Area Secretary
Nottinghamshire Area Ramblers

14th April 2026

**Great North Road Solar and Biodiversity Park
Application for a Development Consent Order (Application Reference: EN010162)**

Revised Public Rights of Way Diversions and Permissive Routes Plan

PUBLIC RIGHTS OF WAY DIVERSIONS AND PERMISSIVE ROUTES PLAN

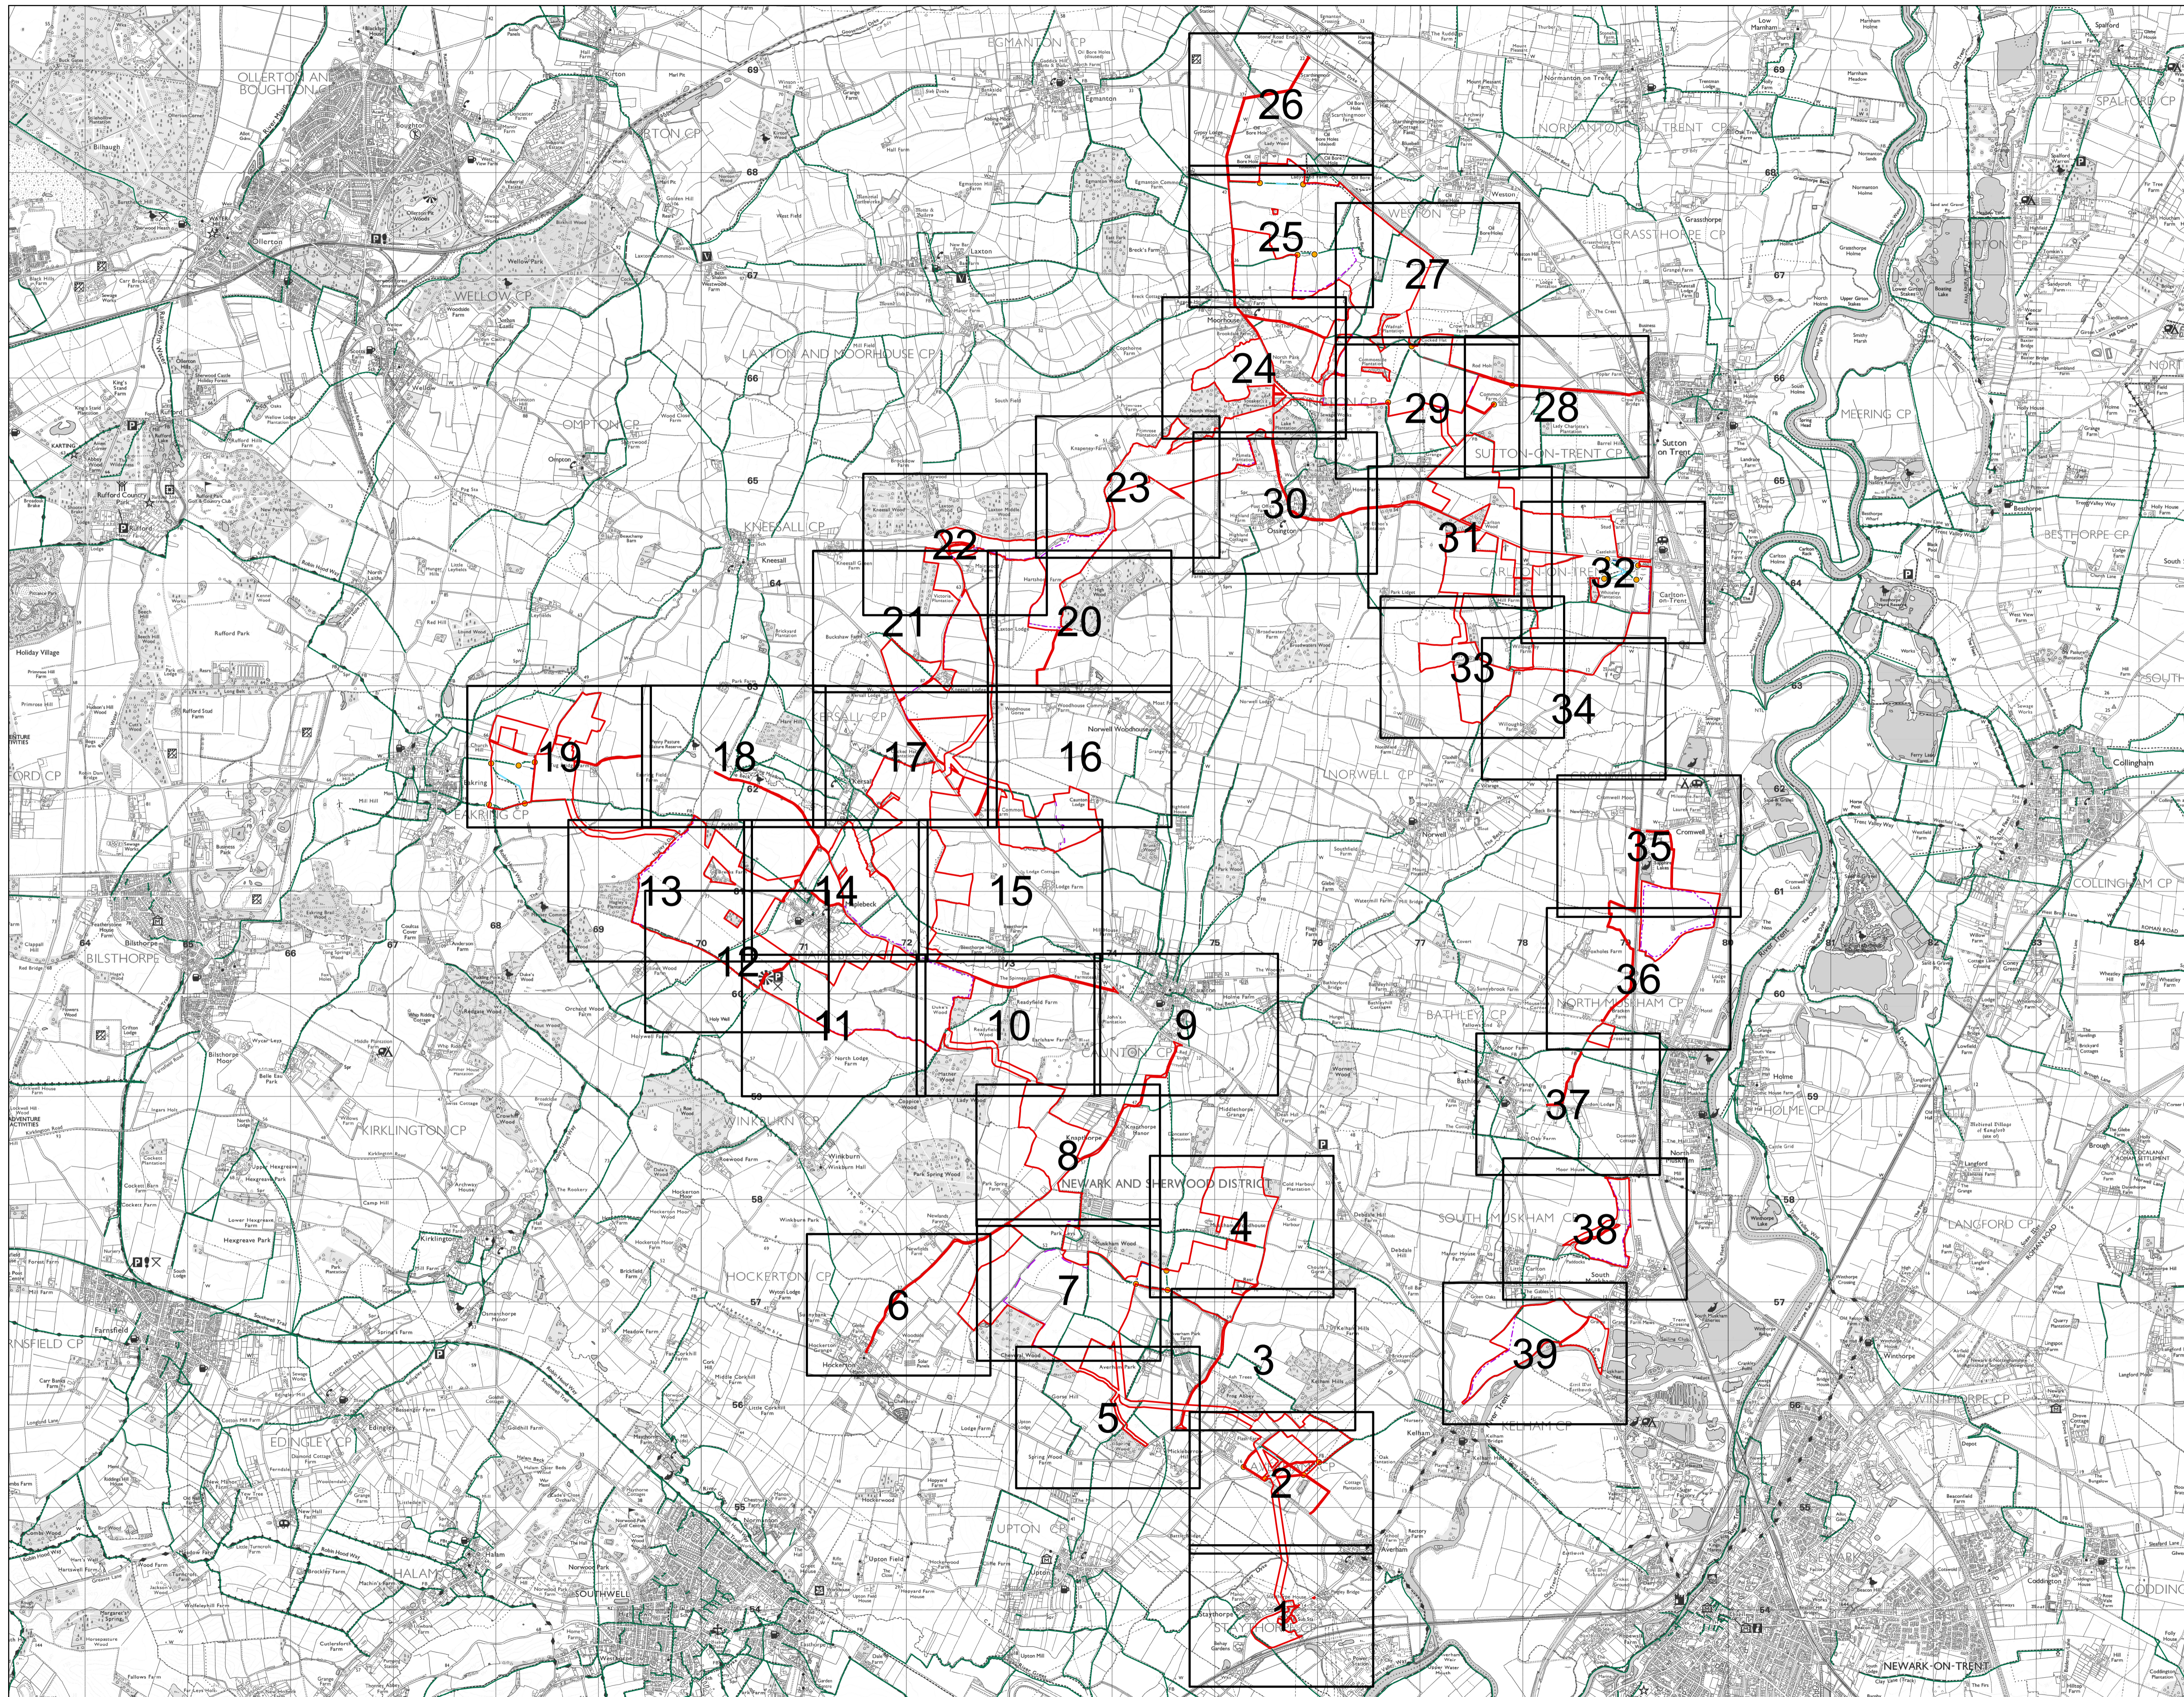
We note that this revision includes “removal of long distance footpaths for clarity”. Long Distance footpaths are a key component of the Rights of Way network. It seems ironic that this revision should take place when the UK Government in March announced the opening of a of a 16th route (The Coast to Coast) to the list of National Trails.

The two long distance **waymarked** footpaths whose designation was removed by the applicant in the latest update are the Robin Hood Way and the Trent Valley Way.

It is therefore imperative that the designation of these long distance footpaths is restored to the plans in order that the impact of what is being proposed is fully considered.
